From: Jennifer Ballinger
Sent: 31 August 2021 15:51
To: Emma Whitley
Subject: 21/02277/F - Moorhouse, Church Lane, Wendlebury

Thank you for consulting the Conservation and Design Team on the above application. The proposed development lies adjacent to the listed building of Elm Tree House.

PROPOSED ELEVATIONS, scale 1:100

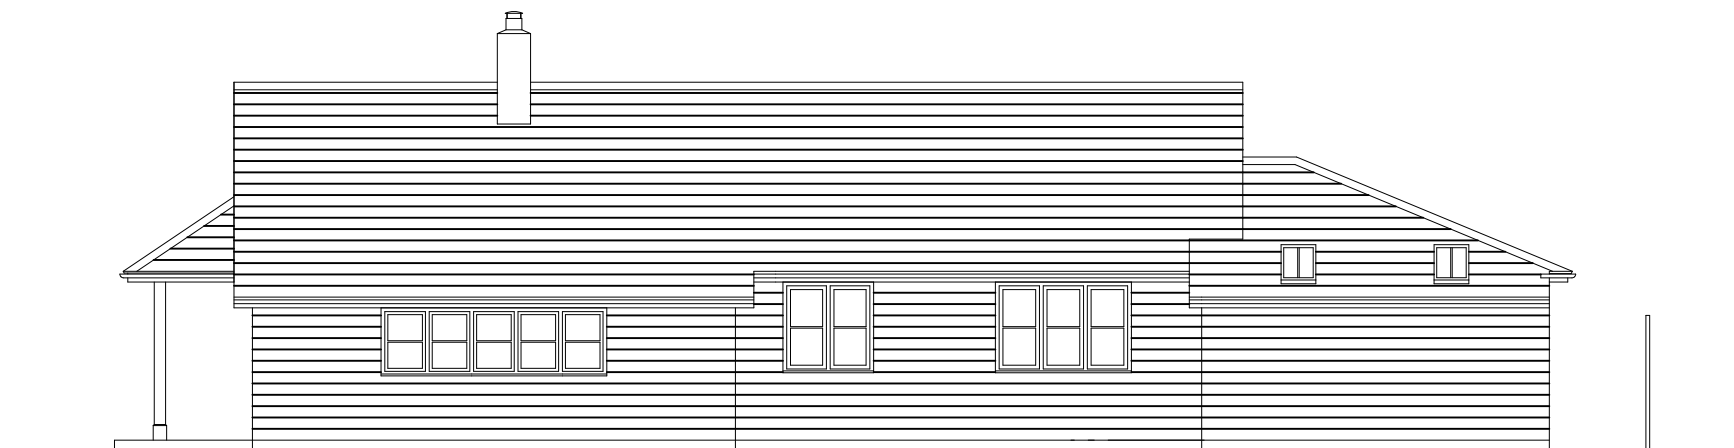
There are, however, concerns with the building being constructed entirely of timber boarding which may look incongruous in relation to the surrounding area and detract from the listed building.
